Date: 14 November 2012

PROPOSED: Residential development. Land at Higher Standen Farm and Part Littlemoor Farm, Clitheroe (3/2012/0942)

Doug Moir
Planning Officer (Archaeology)

The Illustrative Masterplan

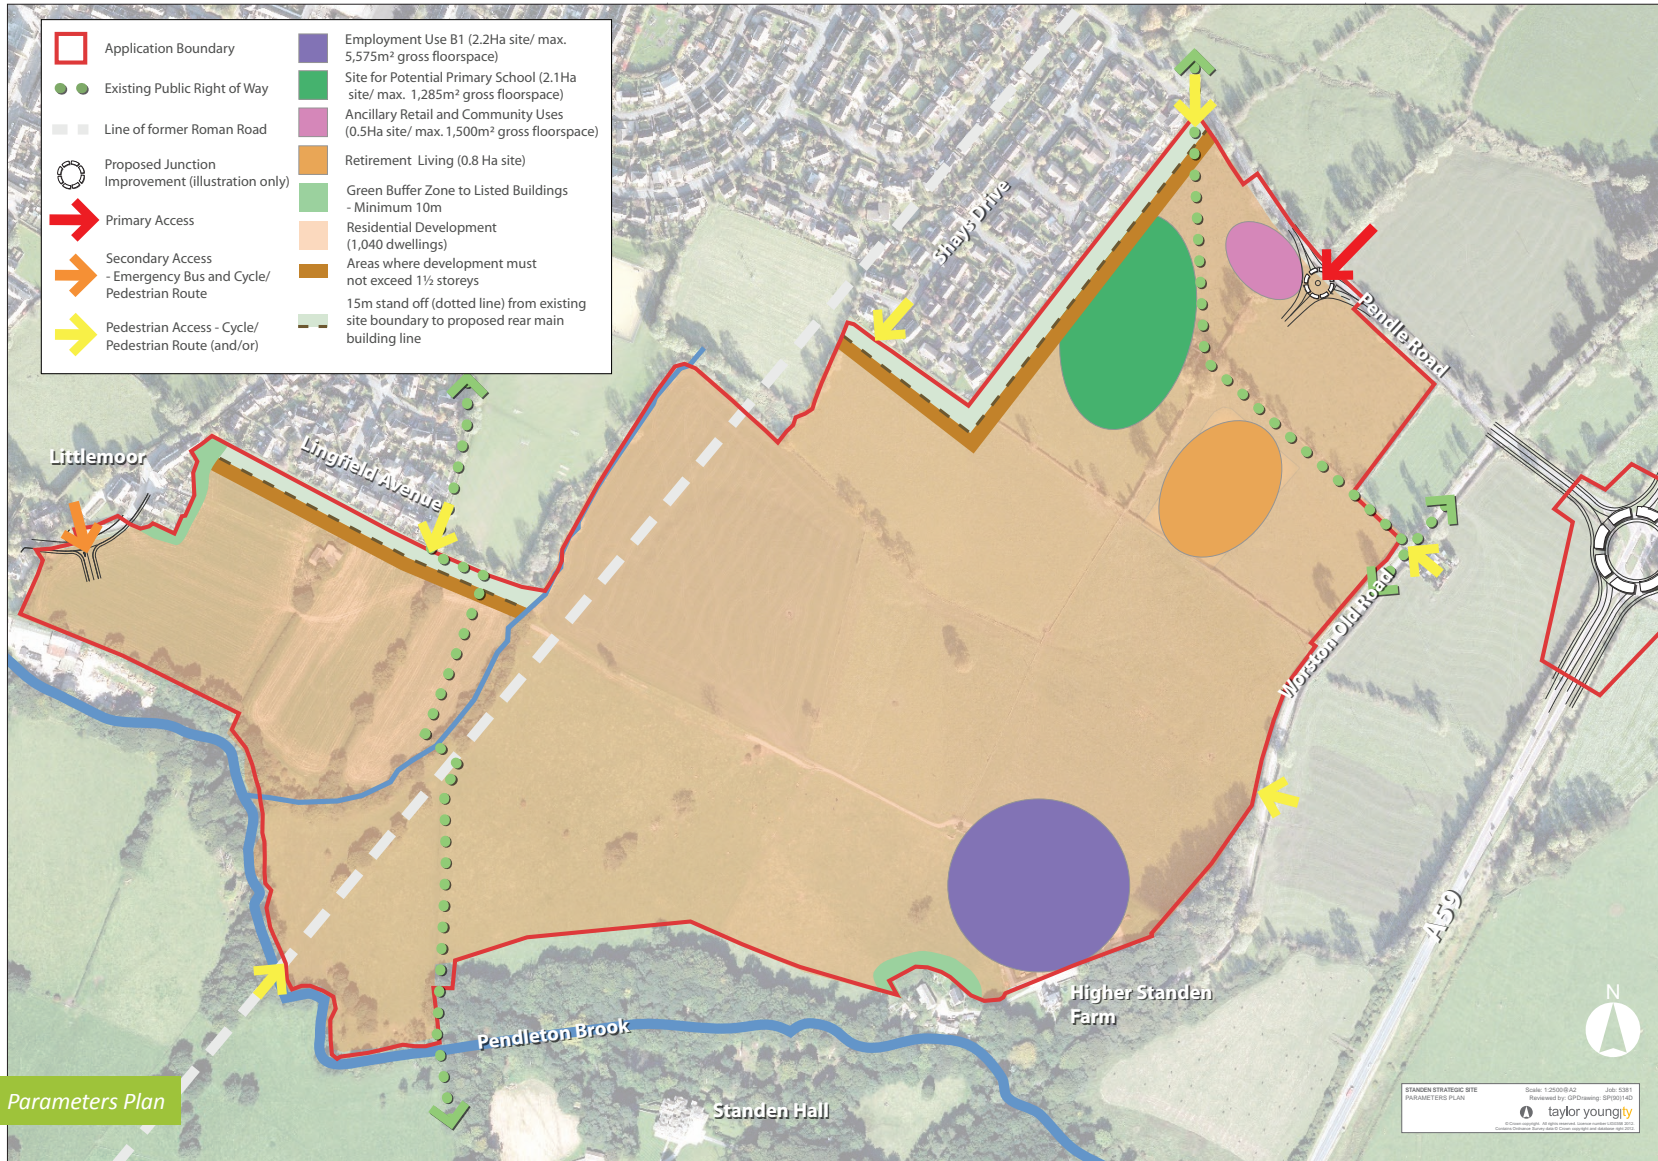
Geophysical survey of the postulated line of the Roman road has identified that the road survives in the form of both a slight upstanding bank as well as buried below-ground archaeological remains. Previous comments on the proposals have indicated that such well-preserved remains should in the first instance be considered for preservation (as suggested in section 8.7 of the Environmental Statement), in this instance by not developing this part of the site, and LCAS would therefore recommend that the proposed housing for this area (as depicted on the Illustrative Masterplan) be relocated elsewhere within the site (i.e. the area to the rear of Shays Drive).

If such a modification to the proposals were not possible then the complete length of the surviving earthworks associated with the road should be recorded by means of a detailed topographic survey, as well as targeted trial trenching whereby information concerning the width of the road, its method of construction and the presence or absence of roadside ditches is recorded.
